PLANNING DEPARTMENT – Development Review Services

November 18, 2014

**RE: Anasazi Ridge, Unit 3
Drainage Report, and Grading and Drainage Plan
Engineer's Stamp Date 10-24-2014 (File: A10D002G)**

SPILLWAY & CONCRETE CHANNEL DETAIL - TRACT A
SCALE: 1"=5'
(CHANNEL CONSTRUCTION AT DRC PER
C.O.A. STD. DWG #2260)

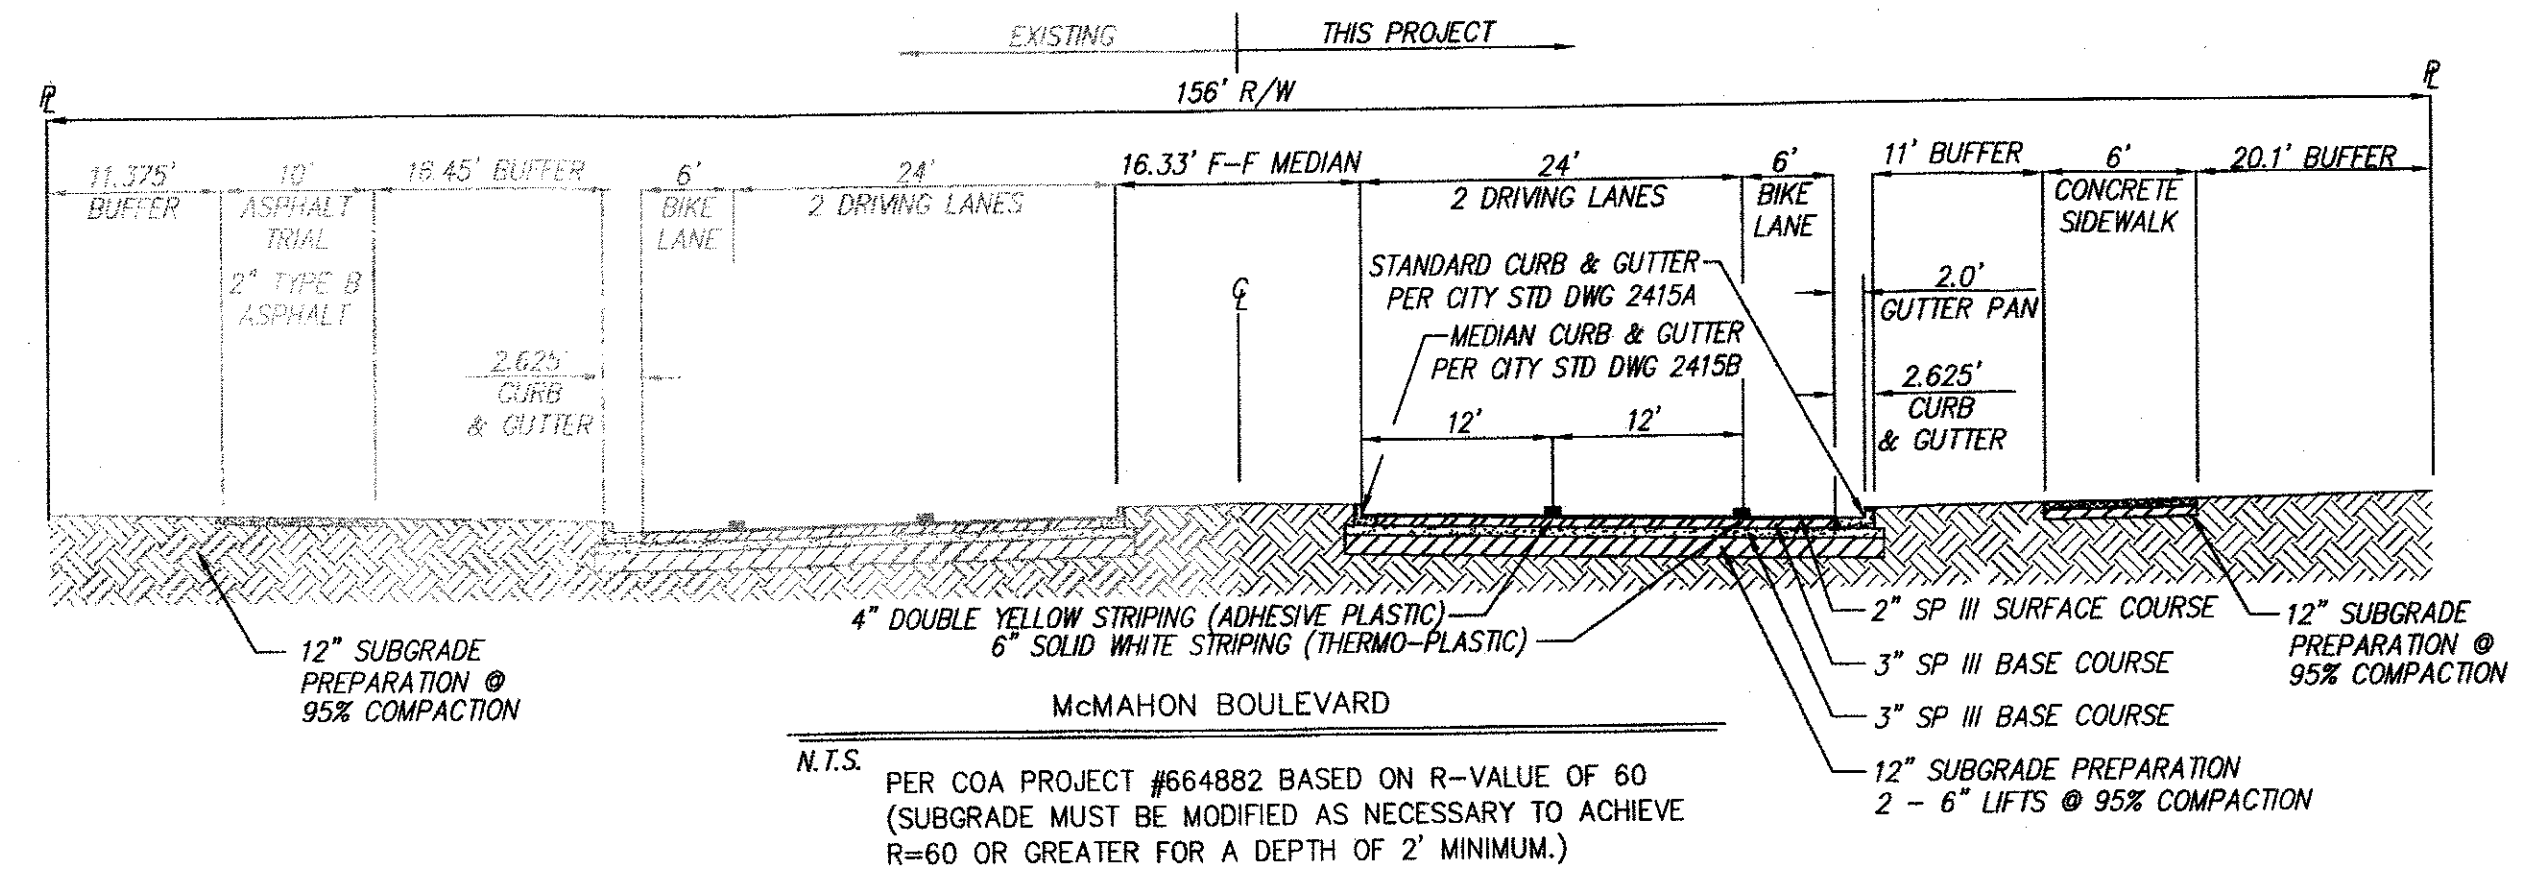
- b. The 10ft wide channel rundown cannot be added to the infrastructure list since the M.O.A. between AMAFCA and the City was never completed.
2. AMAFCA comments for DRB for July 16, 2014 requested that the 100-yr flow rate be shown on the plan for the concrete channel.

Drawing file: FINAL / G&D Plan 2015-02-05.pdf

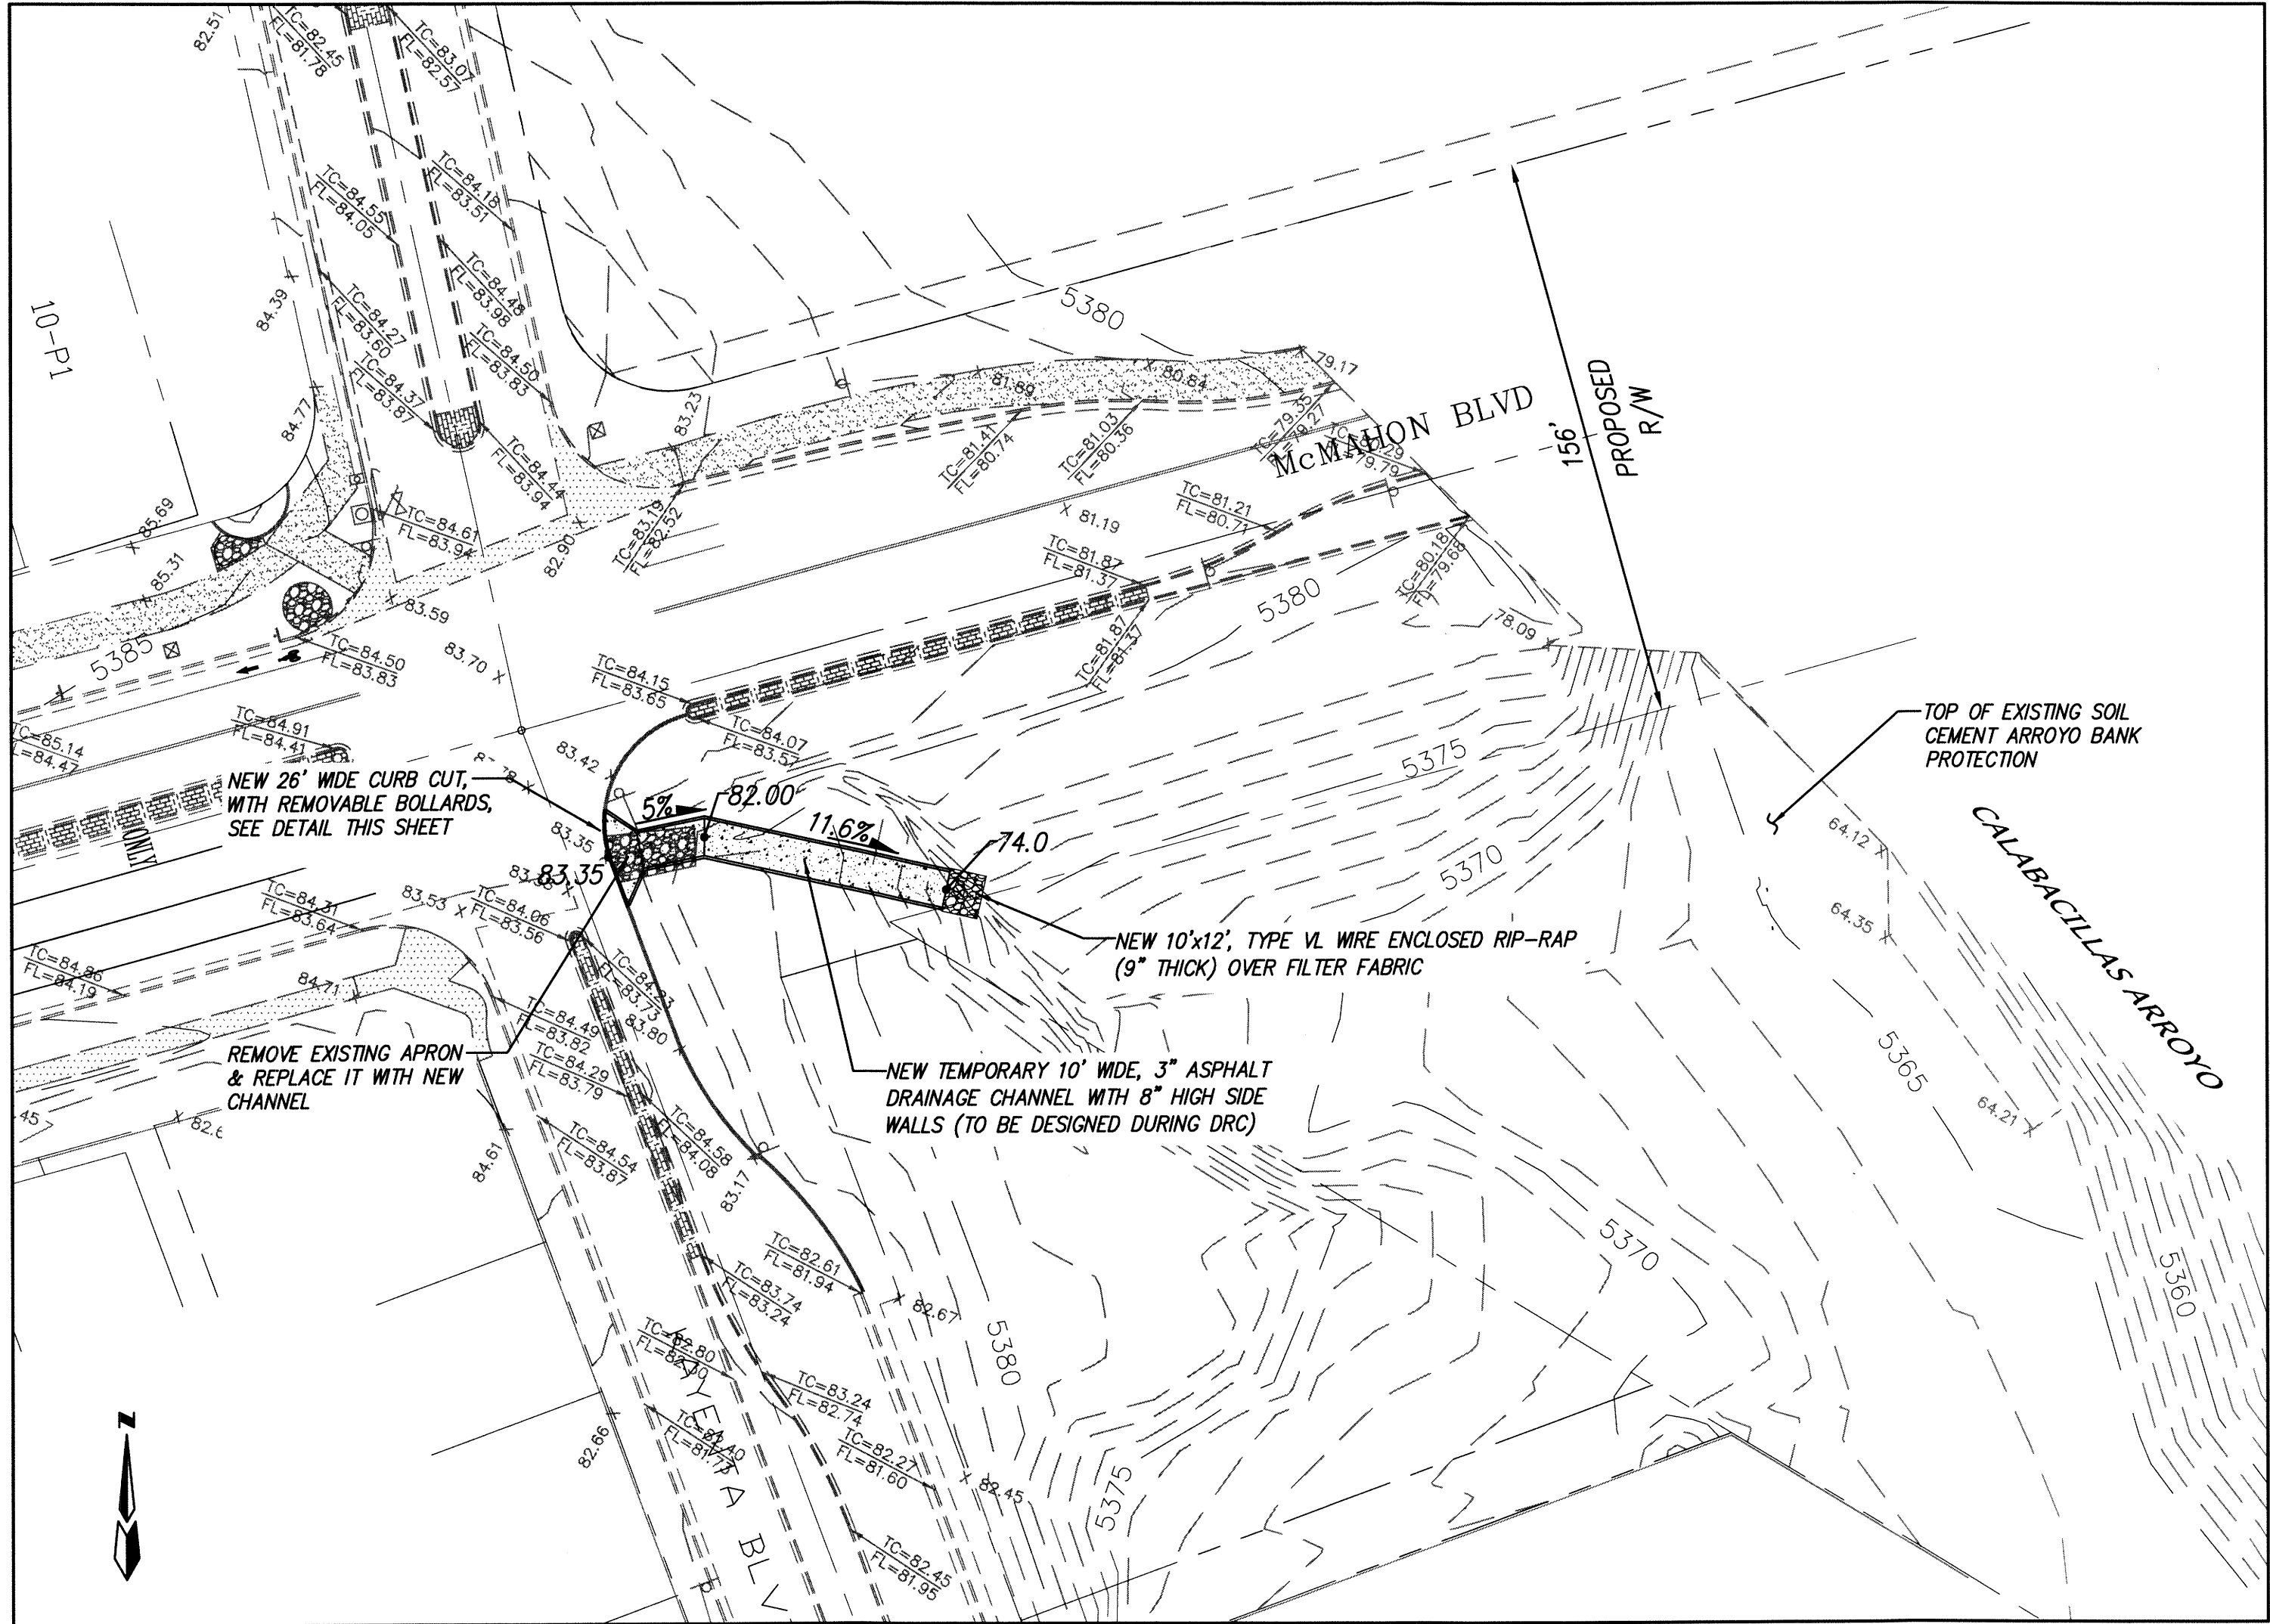
3. Page 3 in the report is duplicated, the first seems to be obsolete.
4. Show proposed contours in Tract E, additional spot elevations in Lot 1, and TW/BW elevations of wall bounding both.

5. Show the Benchmark and Datum information. Verify the existing contours are in the '88 datum.
6. In order that future development to southwest, in Seville Tract 1-A-1, does not discharge into this subdivision via Parsons Blvd., show a waterblock, High Point, or extended proposed grades where Parsons connects to Westside Blvd.

7. Discharge to Calle Vizcaya should utilize the existing concrete rundown, and the discharge details should be shown on the plan.
8. Sidewalk culverts at Sipapu/Westside Blvd should be replaced with an inlet and storm drain to the detention pond.

9. Due to the depth, the detention pond appears to need a fence/railing around it. The pond should be called out on the plan and details shown on the plan.
